**Ref:** SSD-78493518

**RE: SUBMISSION TO SSD-78493518 FOR RESIDENTIAL FLAT BUILDING WITH INFILL AFFORDABLE HOUSING AT 2-8 HIGHGATE ROAD, LINDFIELD**

### Ku-ring-gai Council's objection to SSD-78493518 at 2-8 Highgate Road, Lindfield

Figure 33 Extract of proposed plans showing Ground Floor plans.

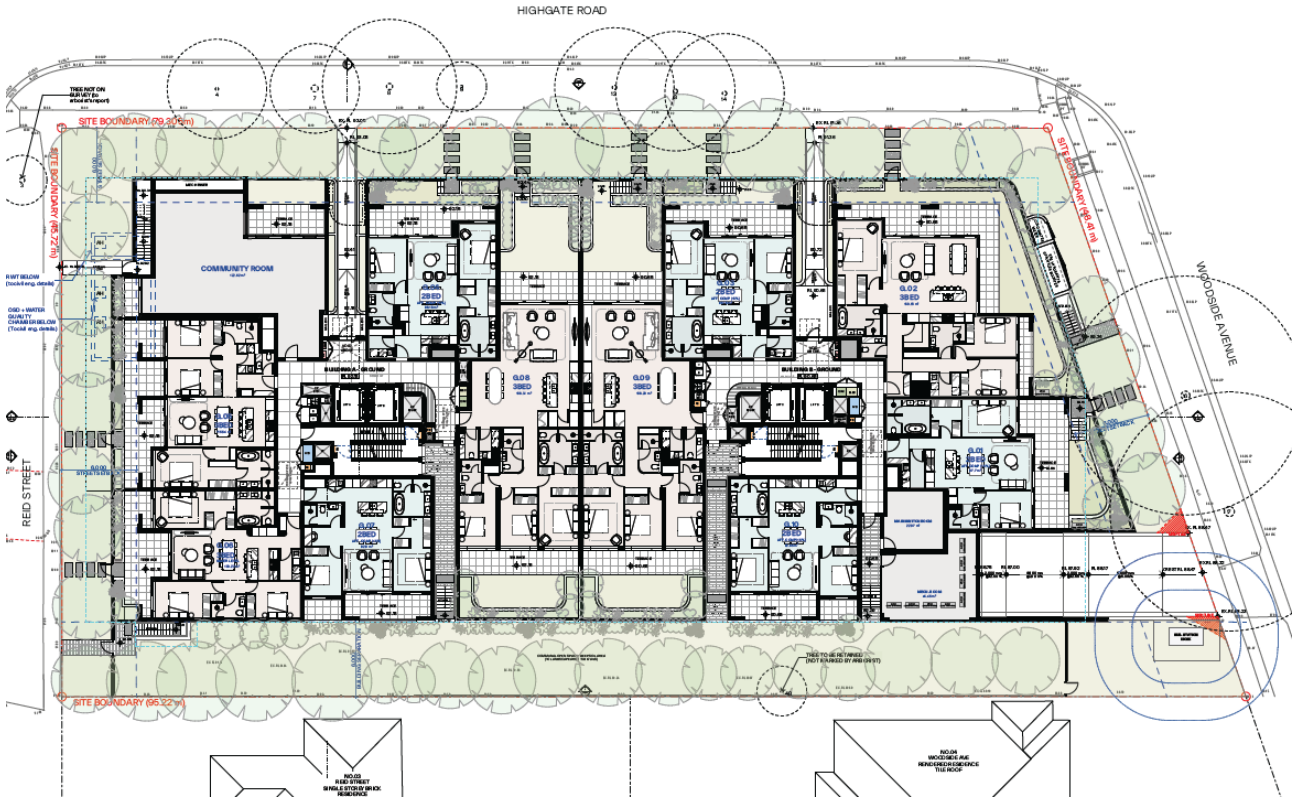
The Applicant has not included the entire corridor on the ground floor adjacent to the main switch room in the GFA, as indicated in red in the diagrams below:

The consent authority needs to carefully review the Applicant's GFA calculations to ensure compliance with the maximum permitted FSR.

A community room is proposed to be located on the ground floor of 'Building A'. Whilst a community room is supported by Council, concern is raised with equitable access for all residents, particularly for mobility impaired residents and in times of inclement weather. For example, in order for a resident residing in 'Building B' to access the community room, they would be required to exit the building to the street, walk along the footpath and then enter the lobby of building A.

Another community room should be provided within 'Building B' or the design amended in such a way that allows for all residents to easily access the community room.

Figure 34 Extract of proposed plans showing Level 1 plans.

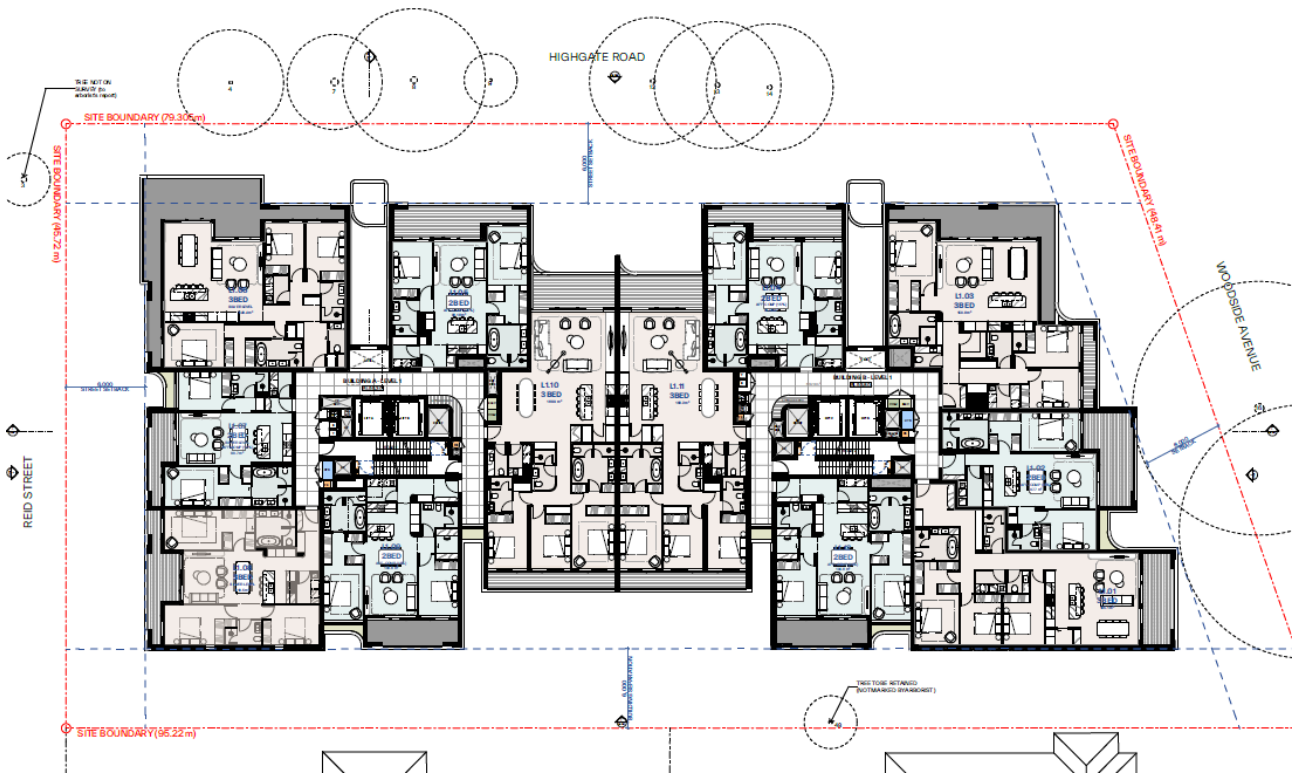
Part 4B of the ADG requires at least 60% of all apartments to be naturally cross ventilated. According to the Applicant's calculations, 62% of the apartments are naturally cross ventilated. However, the Applicant's calculations are incorrect. Apartments that rely on a 'notch' or 'building indentation' cannot be considered as naturally cross ventilated in accordance with the ADG design guidance. 49 (58.2%) of the 84 total apartments are naturally cross ventilated which does not comply with the ADG.

The following apartments marked with a red cross on the Applicant's natural cross ventilation diagrams are not naturally cross ventilated:

Figure 36 Extract of proposed plans showing Level 8 plans.

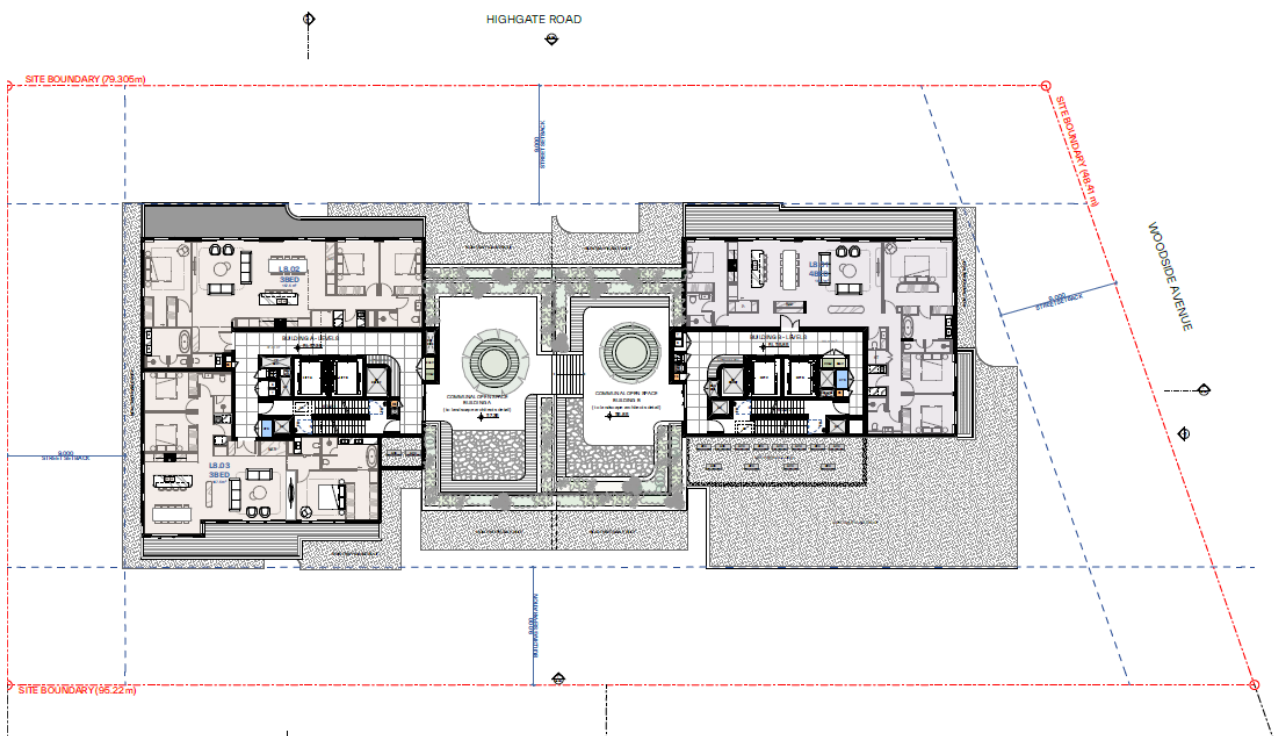
The top storey (9<sup>th</sup> storey) is required to be setback 12m from the south-west rear boundary in accordance with Part 3F of the ADG. The balcony to the top storey (apartment L8.03) is setback only marginally greater than the 9m from the rear boundary which does not comply with the ADG.

This is further exacerbated by the non-compliant 9m setback of the 9<sup>th</sup> storey proposed under the adjacent SSD application, as shown in **Figure 7**. A building separation of 24m at the 9<sup>th</sup> storey is required between the two buildings under Part 2F and Part 3F of the ADG. The two buildings are located only 18m apart which is a significant non-compliance.
